**Consultation Response from KC,
Highways Development Management****2026/91076 Builders Yard, The Old Brickworks, Top O' Th' Bank, Thurstonland, Huddersfield,
HD4 6UY****Demolition of existing building and erection of detached dwelling with ancillary works****Date Responded: 17 August 2026****Responding Officer: Sheila Henley****Responding Ref: 12-16/14****Recommendation: No objection subject to conditions for an evcp, surfacing and
driveway gradient.**

Plan ref: 206 2.002 G planning; 186-93-002 Proposed Swept Path

NOTE: ALL DIMENSIONS SHOWN ARE PROVISIONAL DIMENSIONS ONLY & SHOULD NOT BE READ AS EXACT MEASUREMENTS. THESE MAY NEED TO BE ALTERED DUE TO SITE CONSTRAINTS/ INSPECTION. THE DRAWINGS AND DESIGN ARE THE COPYRIGHT OF LDL LTD & SHOULD NOT BE RE-PRODUCED WITHOUT PRIOR PERMISSION

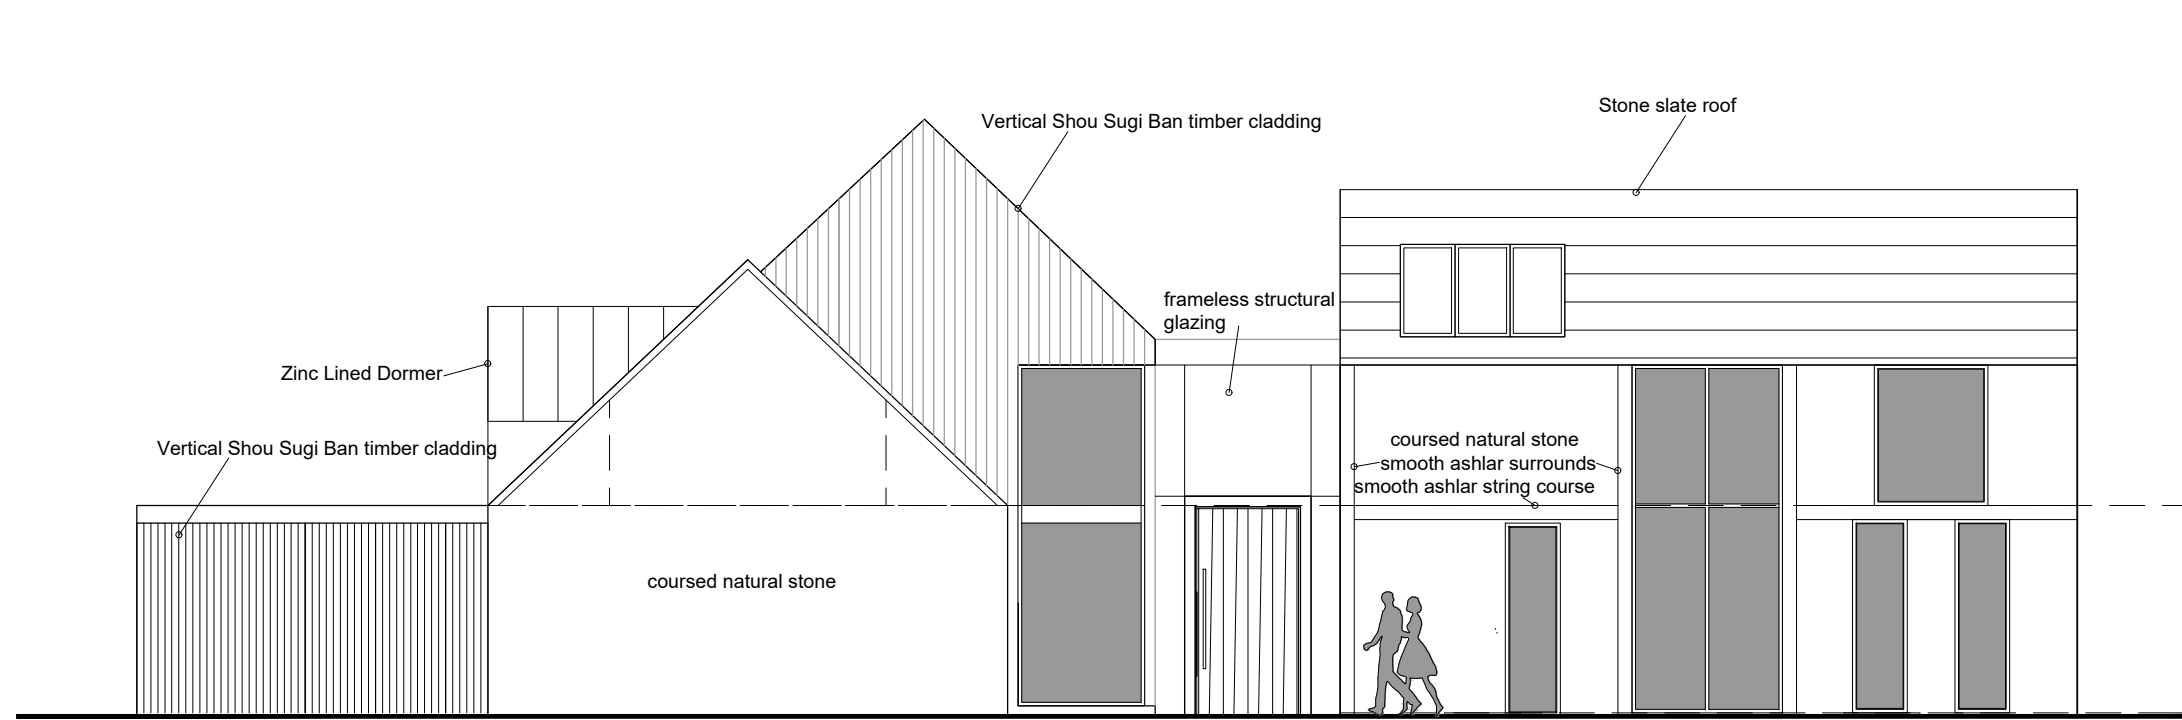
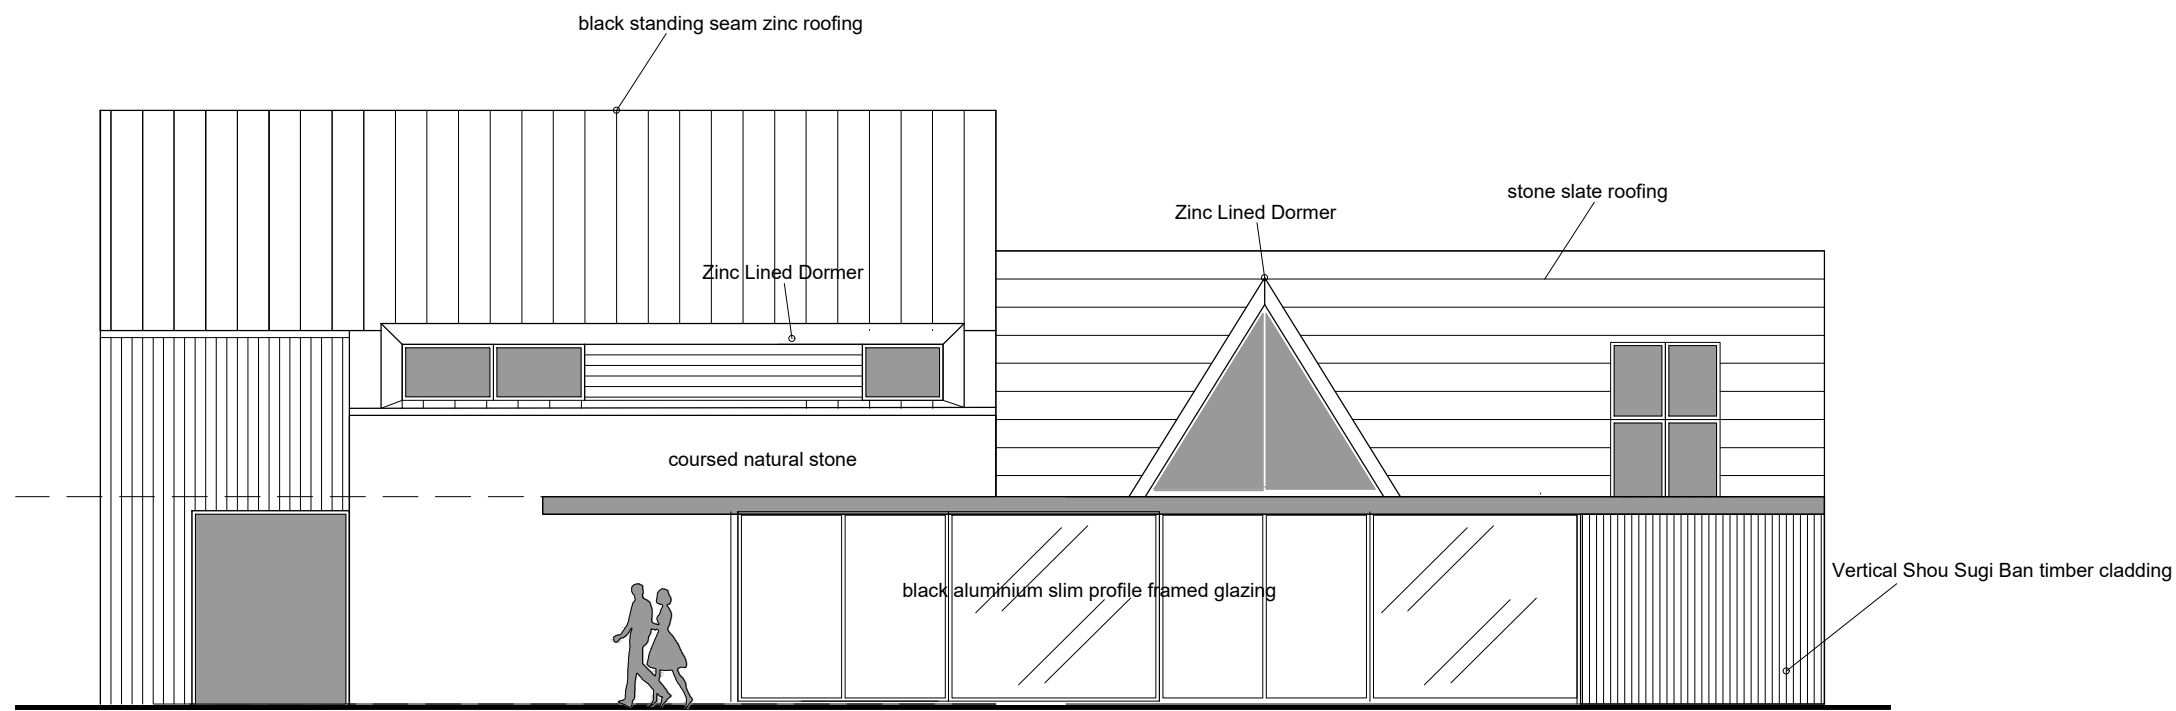
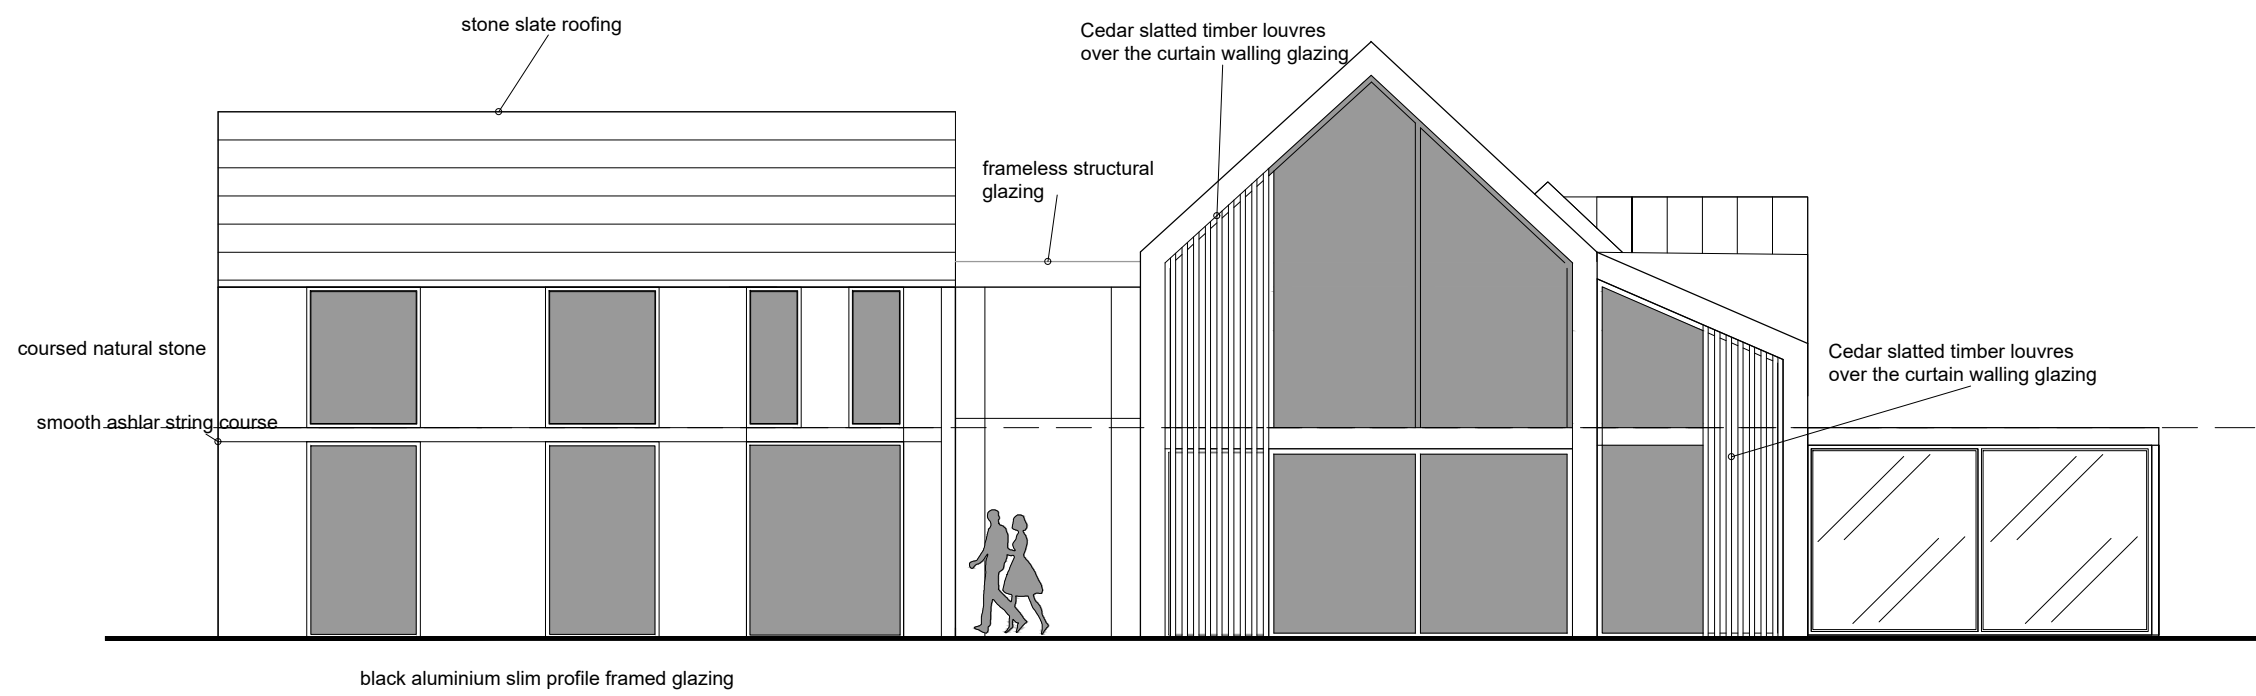
To support policy LP20, Active Travel objectives and encourage more choice, cycle parking could be provided within the garages to provide at least one spaces as desired under the Kirklees Highway Design Guide SPD or preferable to one space per bedroom under later guidance in LTN1/20.

An electric vehicle charging point will be necessary, preferably to be positioned in a garage to further encourage sustainable travel and lower emissions under policies LP20 and LP24.

The site is to be served from an unadopted section of Top O' Th' Bank which serves seven dwellings and a Joiners' shop and commercial usage of the builder's yard. There would be a new driveway access shown as ungated, but of a width suitable for two-way movements and shared use between pedestrians and vehicles. This section of the street is unsuitable for adoption and would remain privately managed. It is suggested that the access is gated and that these open inwards

Within the site there is to be a new driveway leading to the building entrances, including a garaging area with two singles with an internal size of 6.7 x 3m. The new driveway is of ample size to allow for external parking and turning as well as shared use between pedestrians and vehicles. Its gradient should not be greater than 1 in 12.

The garages too are larger, internally, than suggested in the KHDG SPD of 6 x 3m and would be suitable to count towards car parking and the storage of cycles and other items.

Any new surfacing should be of a porous material or a surface water drainage scheme provided.

- a) Electric Vehicle Charging Point: Development shall not be occupied until an Electric Vehicle Charging Point has been provided in accordance with a scheme that shall have been submitted to and approved in writing by the Local Planning Authority. The approved facilities shall thereafter be retained for the lifetime of the development.

- b) Surfacing: Development shall not be occupied until all areas shown on the approved plans to be used by pedestrians and vehicles on the approved plans have been laid out, surfaced in a porous material or drained, such that loose materials and surface water does not discharge or transfer onto the adjacent street, and shall thereafter be retained and maintained for the lifetime of the development.

- c) Maximum Driveway Gradient: The gradient of the driveway shall not exceed 1 in 12.5 (8%).
